RE: **Oakland Heights Subdivision**
7420 Oakland Ave. NE
Engineer's Certification Date: 3/24/17
Hydrology File: C19D063

Based upon the information provided in your submittal received 3/28/17, the Engineer's Certification is not approved for Release of Financial Guarantee. The following comments must be addressed prior to Release of Financial Guarantee:

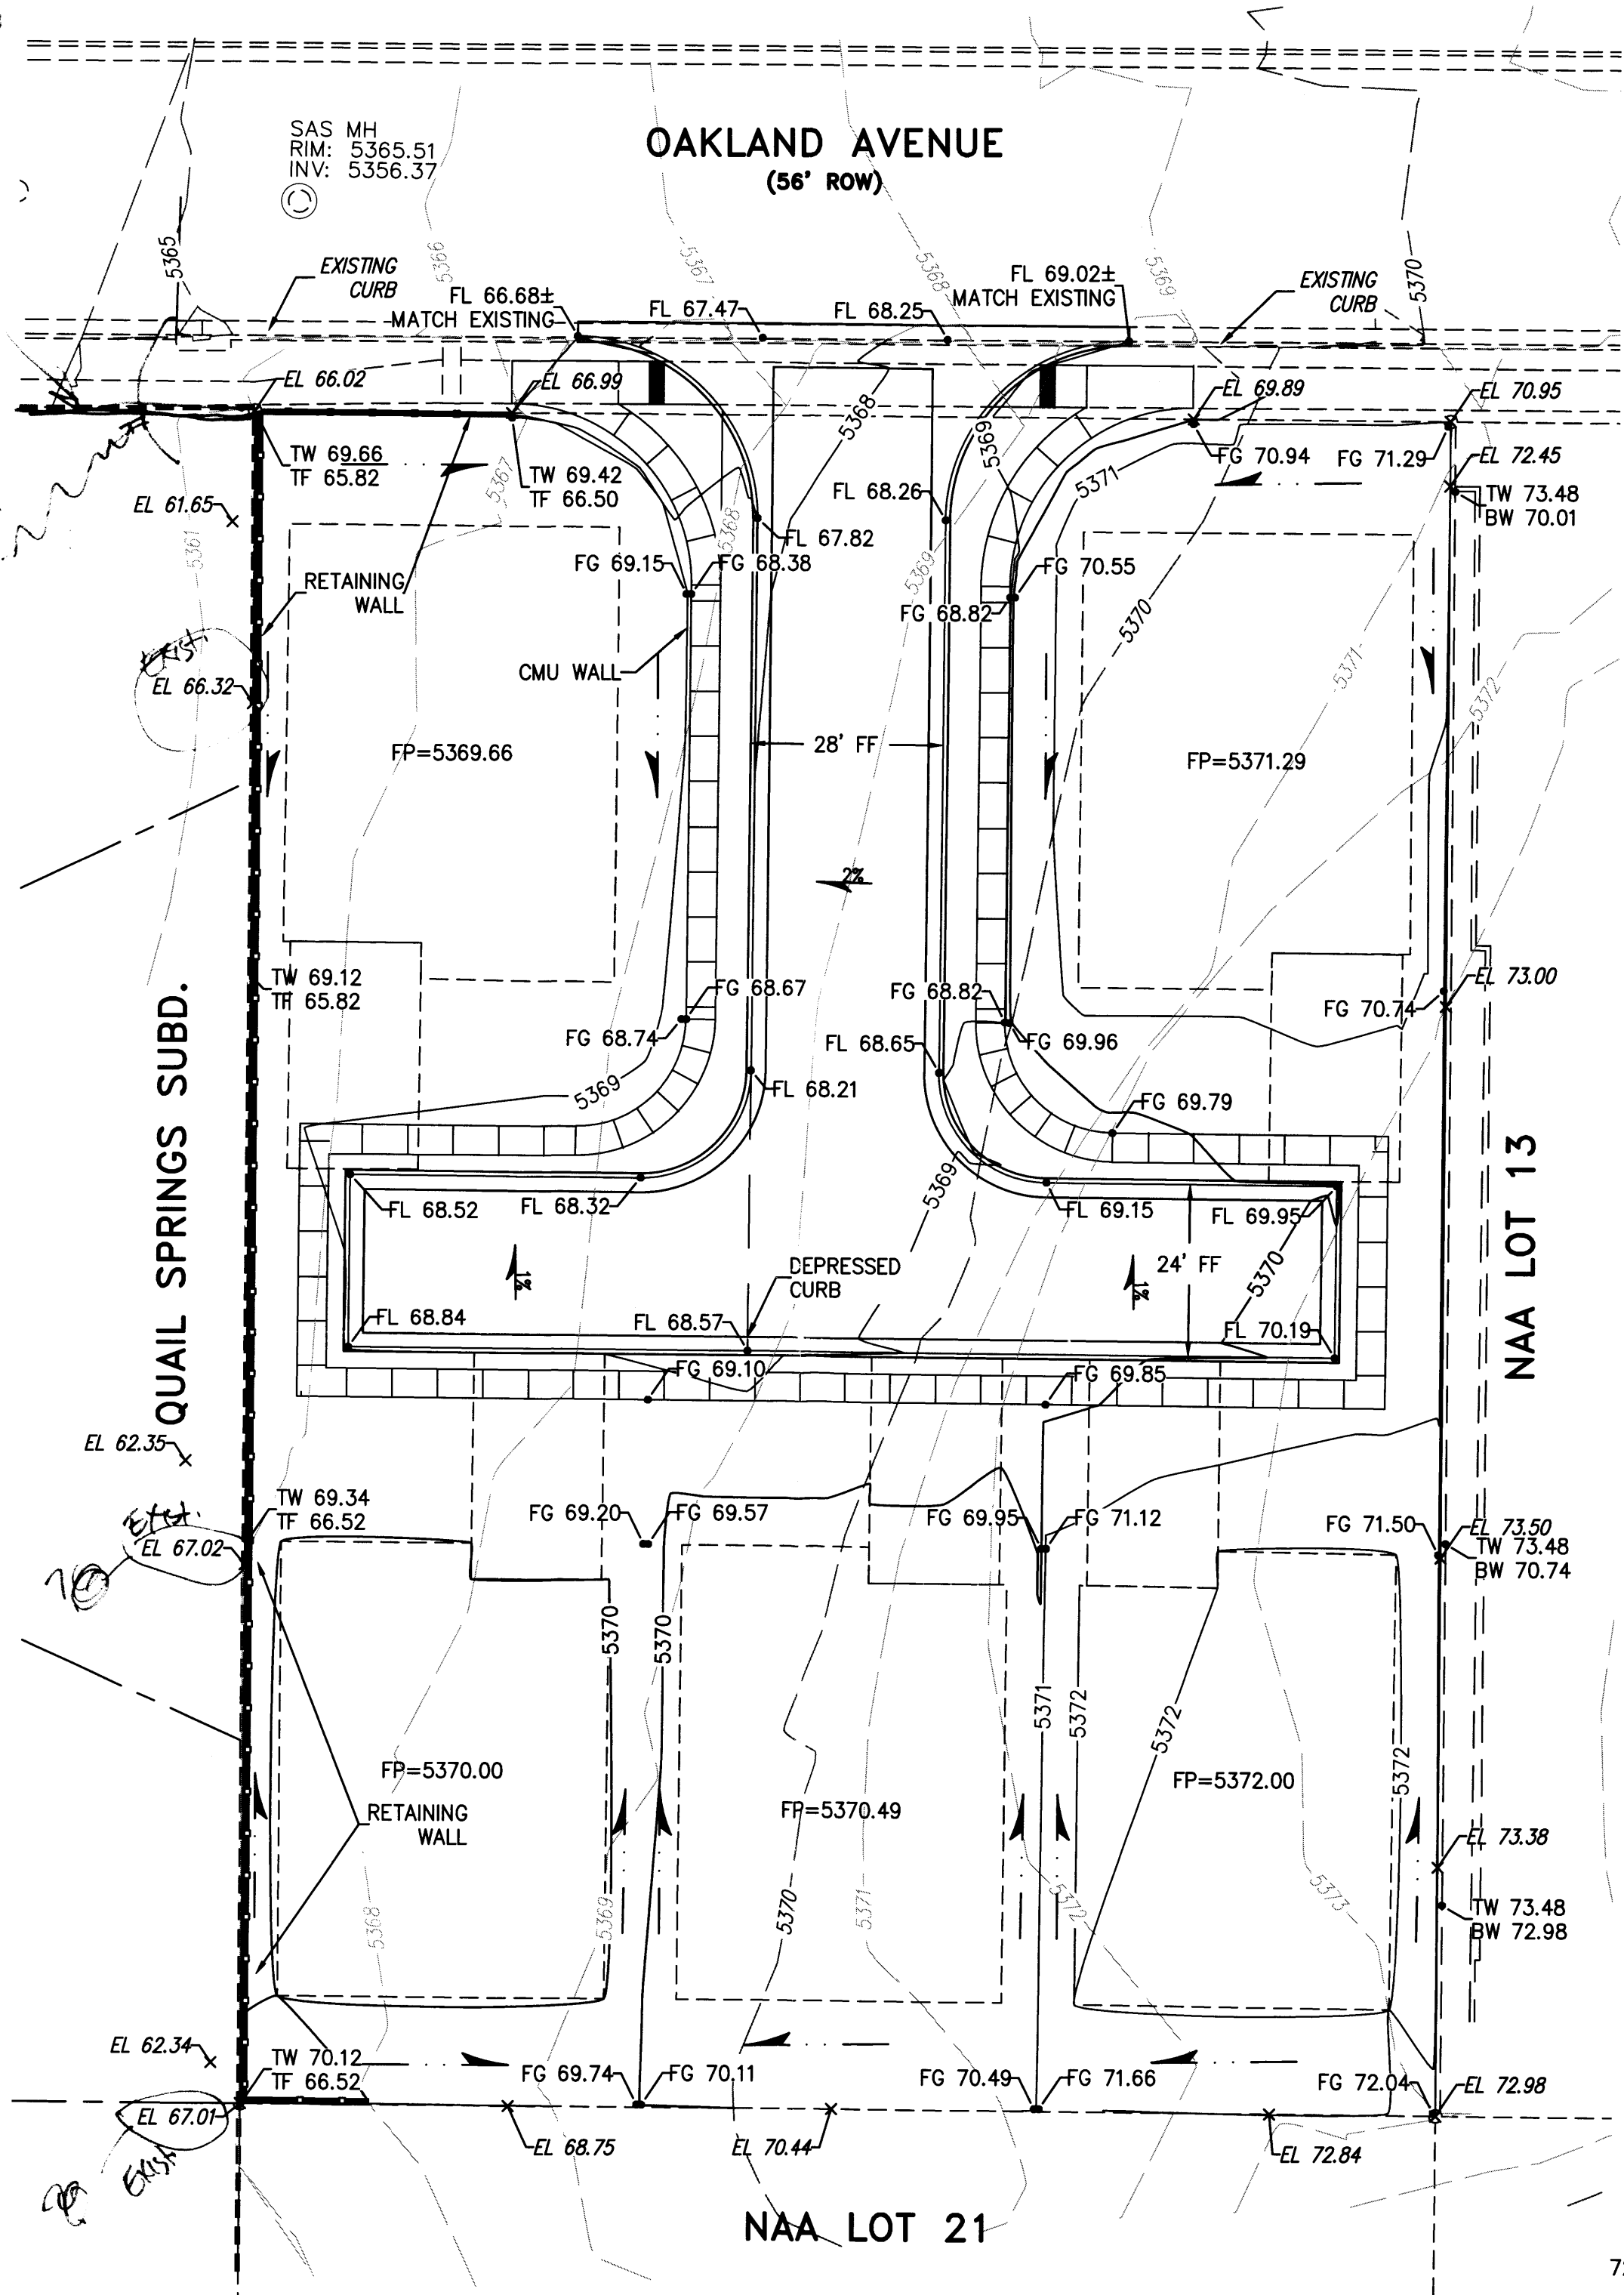
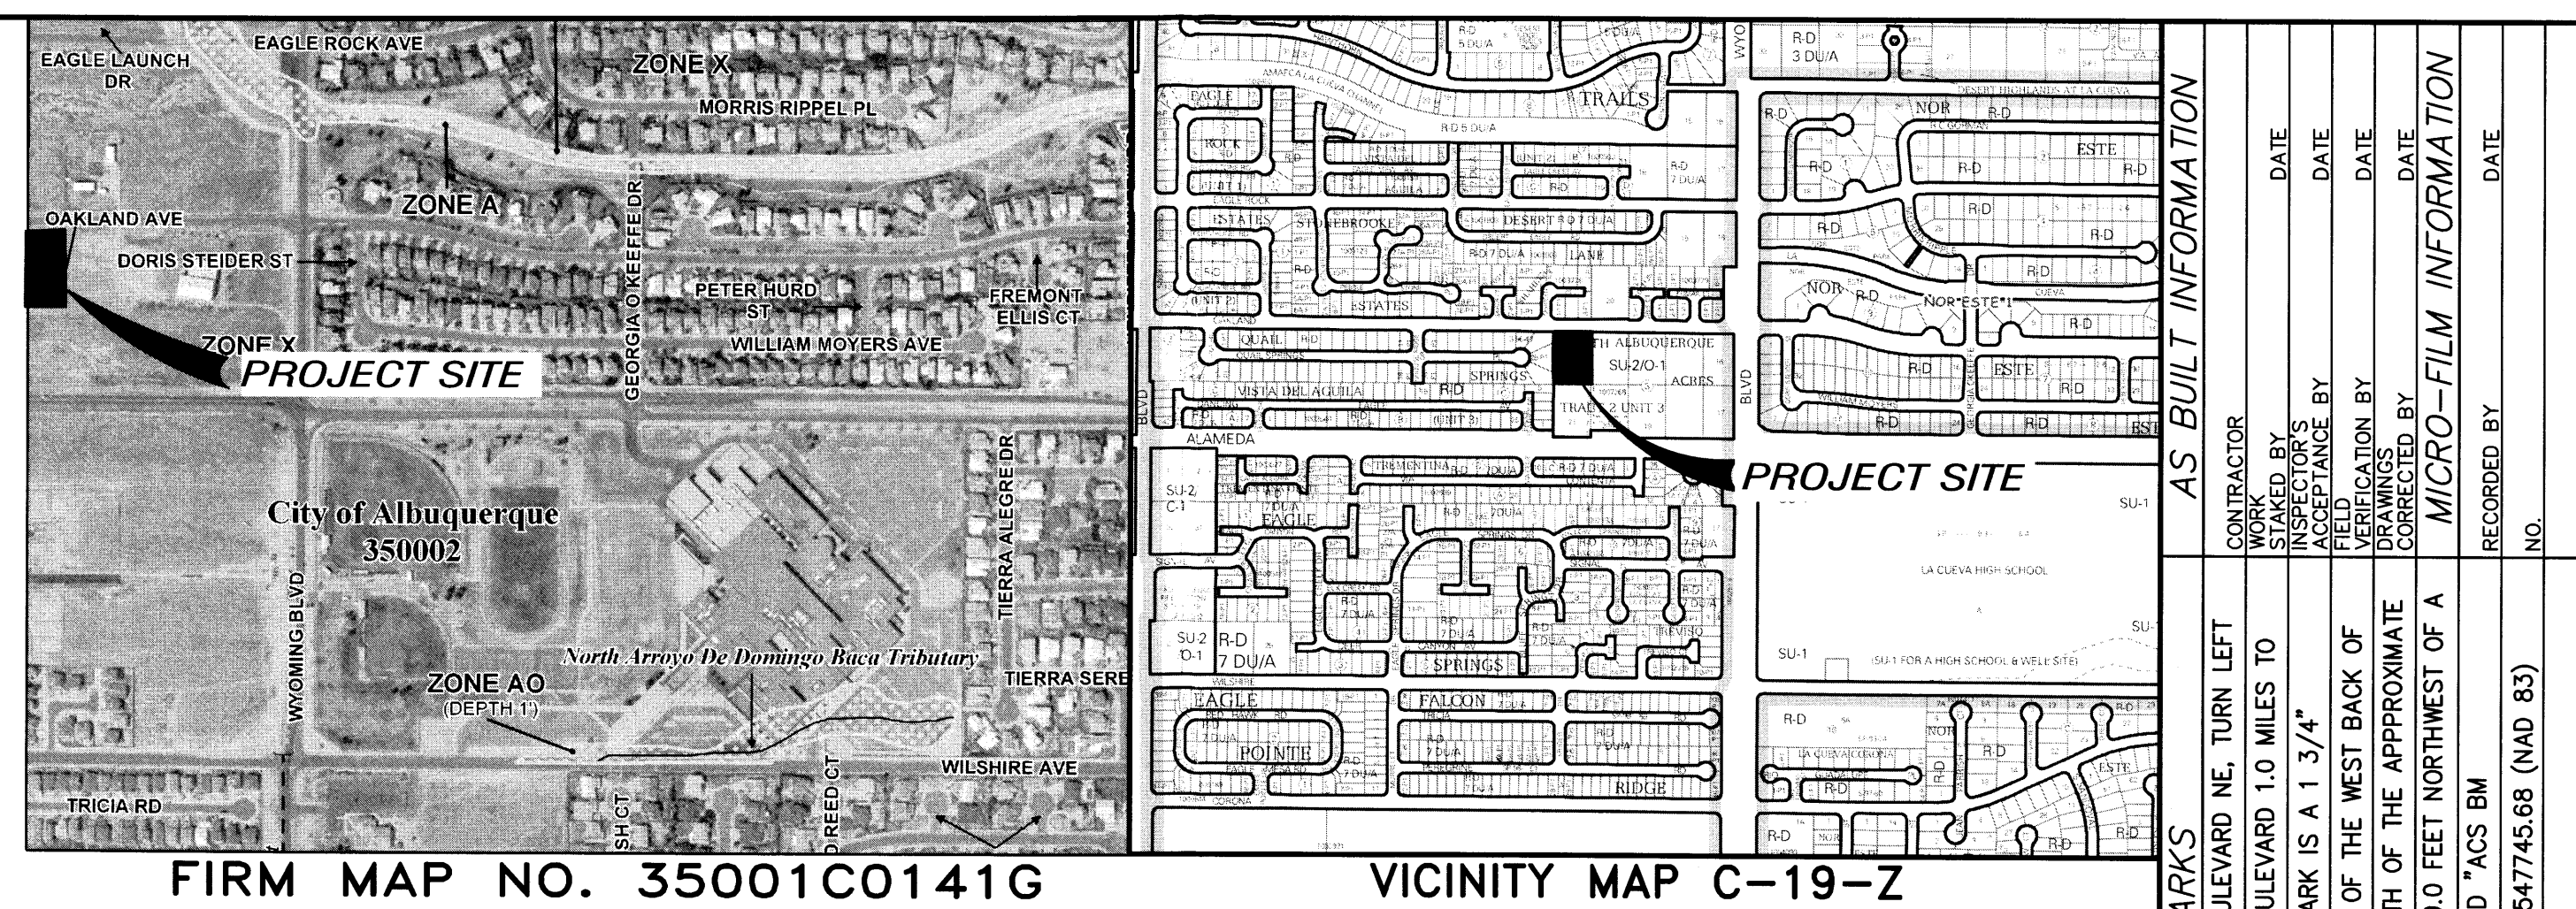
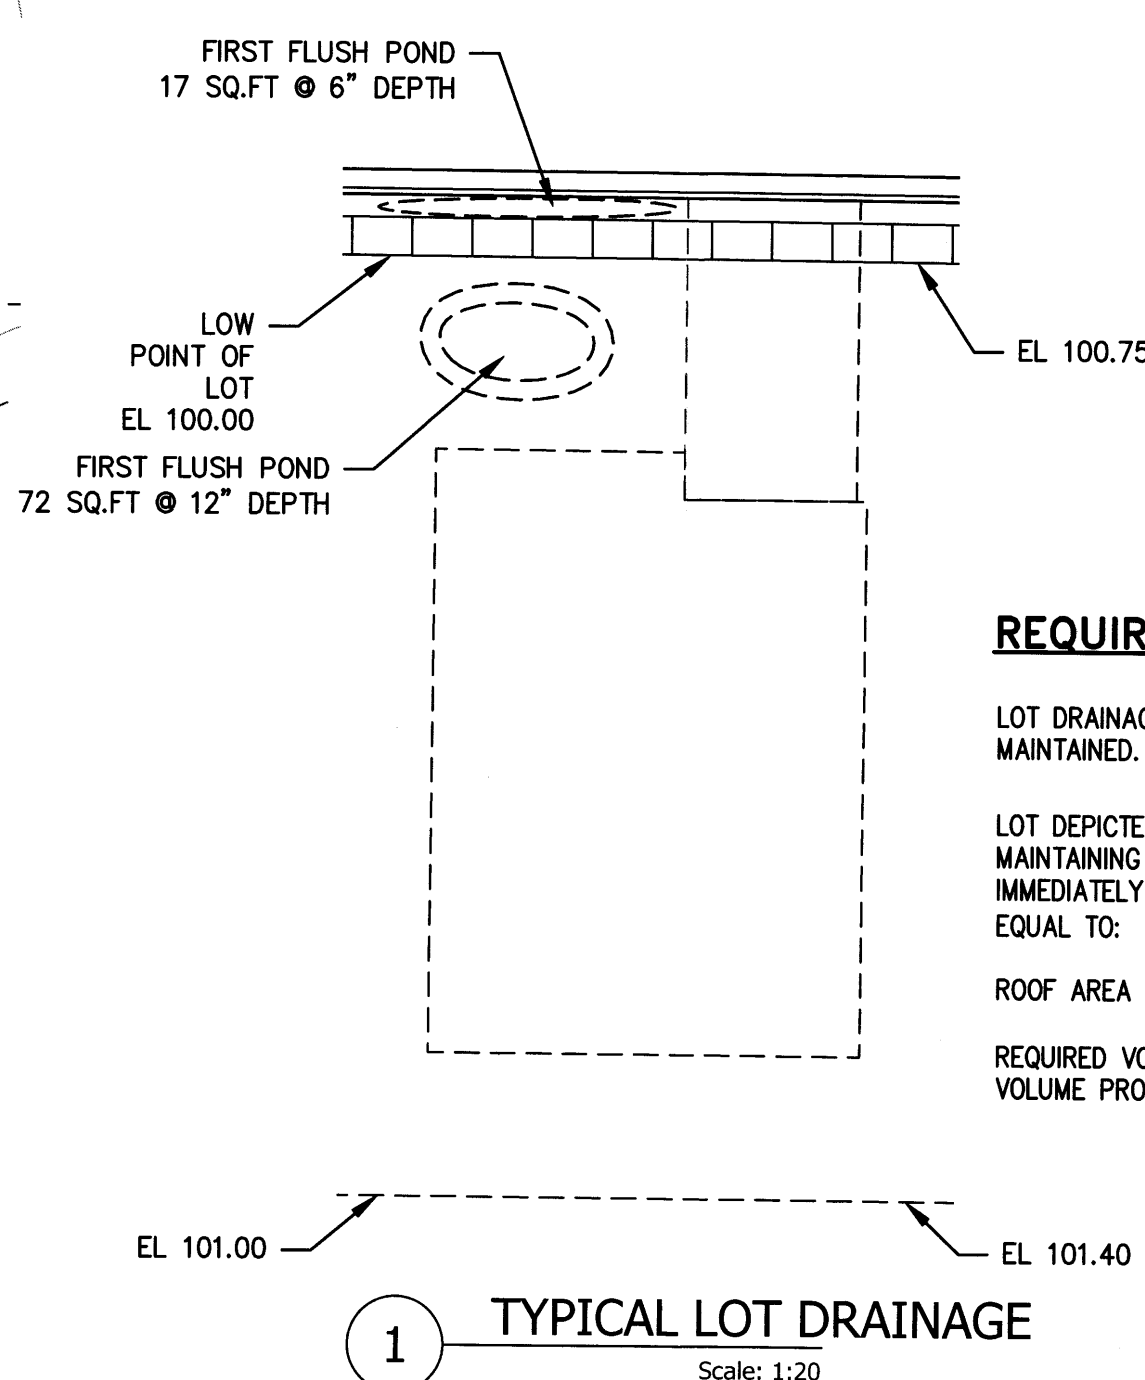
- a. Northeast corner of site. There is a low spot here that will pool water against the retaining wall, which is adjacent and up-gradient of the neighboring property (Quail Springs subdivision). This area is also graded back to this corner instead of towards Bernal Court.

- b. West end of the Bernal Court Hammerhead. There is a low spot here that will pond water against the retaining wall instead of forcing it out onto the hammerhead. Same issue with ponding against a retaining wall that abuts the neighboring property.

- c. Southwest corner of the site. Similar to item 2a, but less extreme. There is a low spot that will pond against the retaining wall instead of draining to Bernal Court.

3. The swales need to be bladed out to drain the site according to plan. Some of the areas are graded opposite the direction shown in plans and have flowlines set against the walls.
